KITTITAS COUNTY DEPARTMENT OF PUBLIC WORKS

MEMORANDUM

TO: Jeff Watson, Community Development Services
FROM: Christina Wollman, Planner II *W*
DATE: September 3, 2013
SUBJECT: Brady BL-13-00019

The Public Works Department has reviewed the Request for Boundary Line Adjustment Application. In order to ensure that it meets current Kittitas County Road Standards, the applicant needs to provide the following prior to final approval:

BOUNDARY LINE ADJUSTMENT
 PREPARED FOR
 MATT COE
 A PORTION OF THE EAST 1/2,
 SECTION 8, TOWNSHIP 18N., RANGE 19E., W.M.

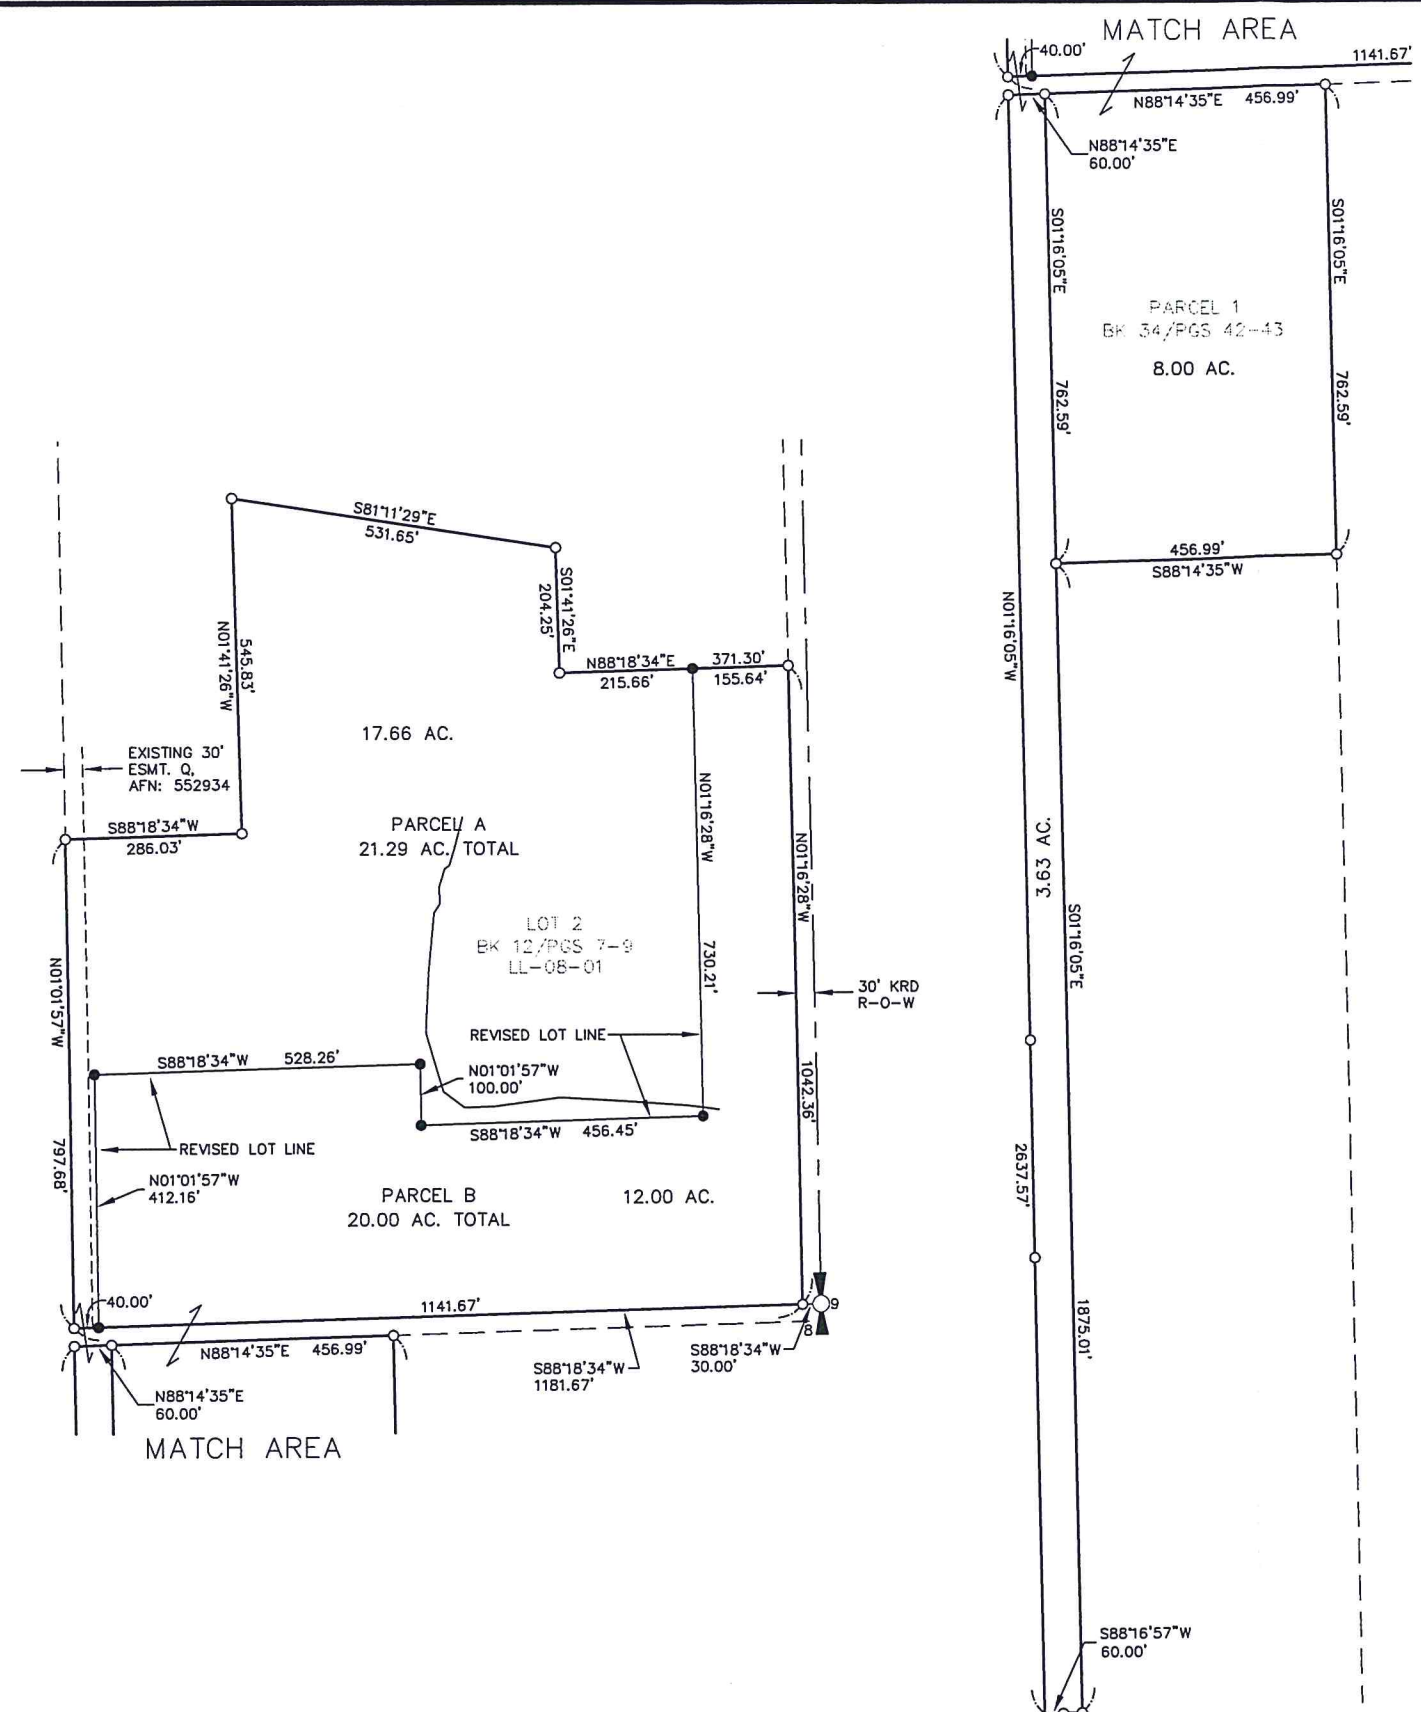
1. An access easement crossing the KRD lateral at the private road or a KRD crossing permit for a separate location shall be required prior to final approval to ensure legal access to the new section of the parcel.
2. A revised legal description that describes the final configuration of the subject property shall be required.
